FAO. R. Hughes.
Planning R. Valley.

app. 3/2022/0834.

Cow Trees Barn.

| DRAWING | Proposed Floor Plans & Elevations | | | | |

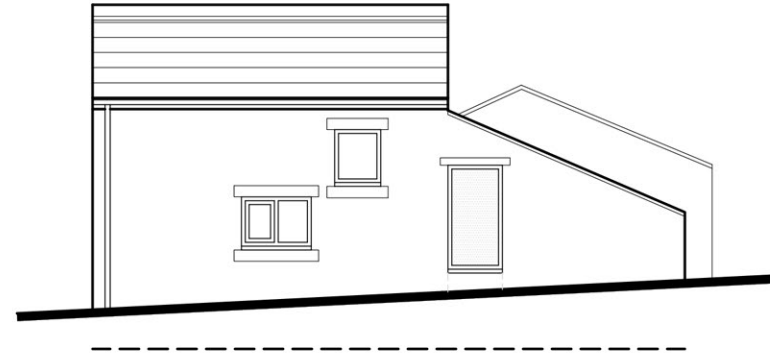
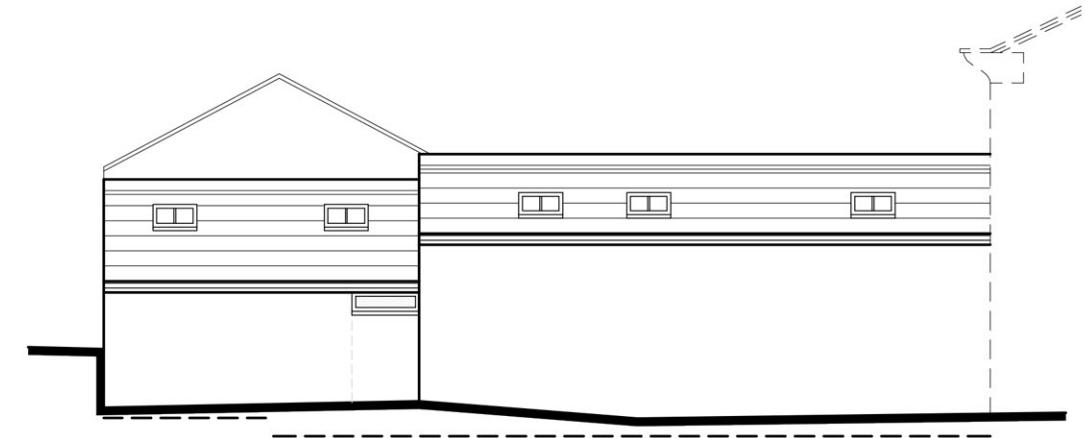
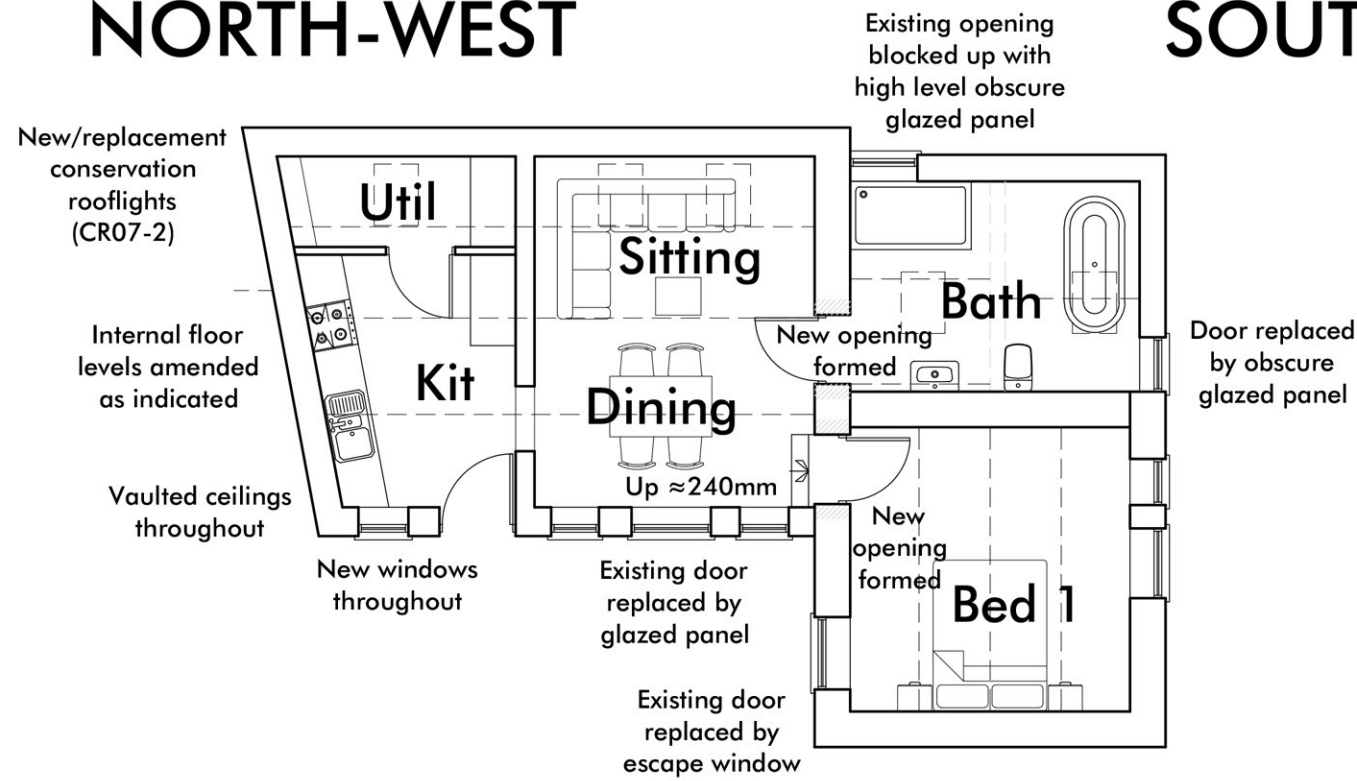
3. It's a listed building case was taken to stick rigidly to the rules when converting the barn, by ~~[REDACTED]~~. This proposal shows a raising of the roofline at one end which was refused before. There should be no change in the type of building materials on walls or roofs, no addition or change to the size of windows or to add anything considered detracting from the architectural integrity of this group of buildings on the periphery of the Clatburn Conservation Area.
